Your Ref: 2020/93308  
Our Ref: W014055

26th November 2020

**Former Spotted Cow Pub, New Hey Road, Huddersfield - Erection of an A1 foodstore with associated parking, servicing areas and landscaping**

DRAWN	KK	DATE	22/07/2019
CHECKED	TM	SCALE	
APPROVED	KGP	AS SHOWN @	A1
DRAWING NUMBER	09-122-502		REVISION
			E

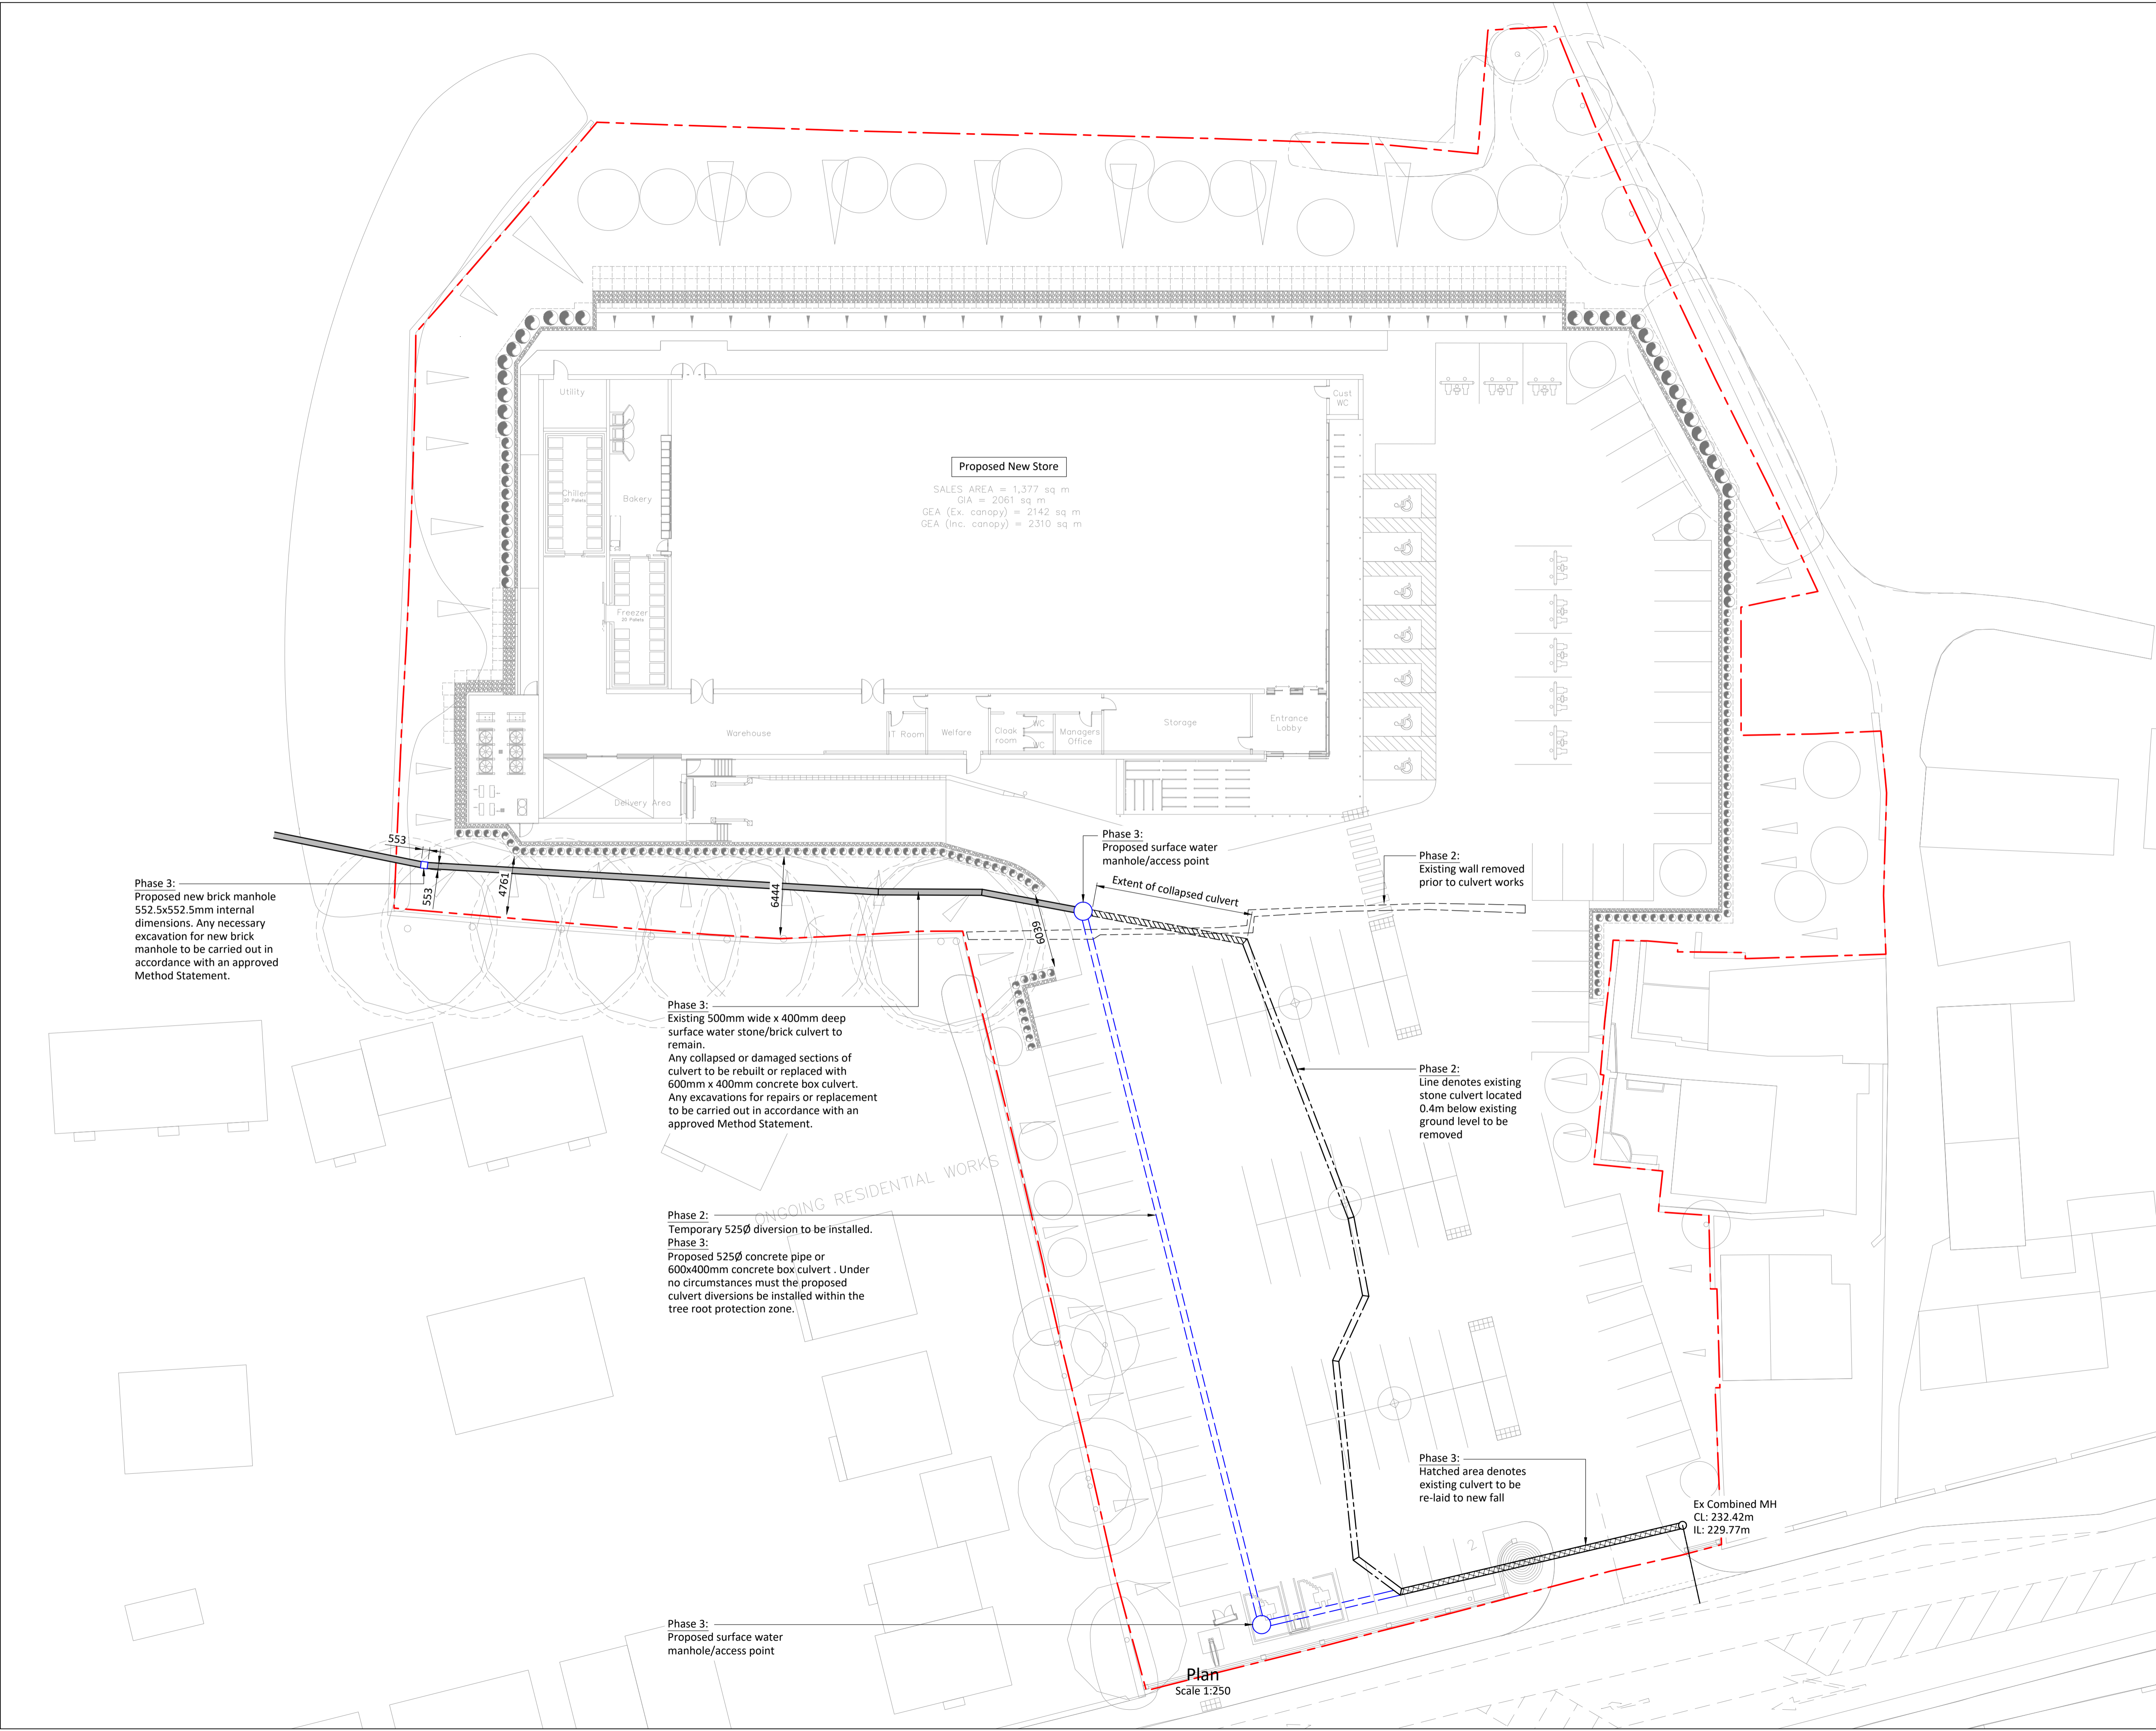
The drainage details submitted on drawing 09-122-502 (revision E) dated 21/09/2020 that has been prepared by Beam Consulting require amendment, but if planning permission is granted, the matter can be dealt with via condition. The following points should be addressed:

- 1) the submitted drawing appears to show a culvert diversion which ultimately discharges to the public combined sewer network.
- 2) the culvert diversion must not result in any increased flow rate from the culvert to the public sewer network.

3) The developer will need to prove existing culvert flow capacity and the proposed diversion flow capacity as evidence that there will be no increased discharge to the public sewer network.
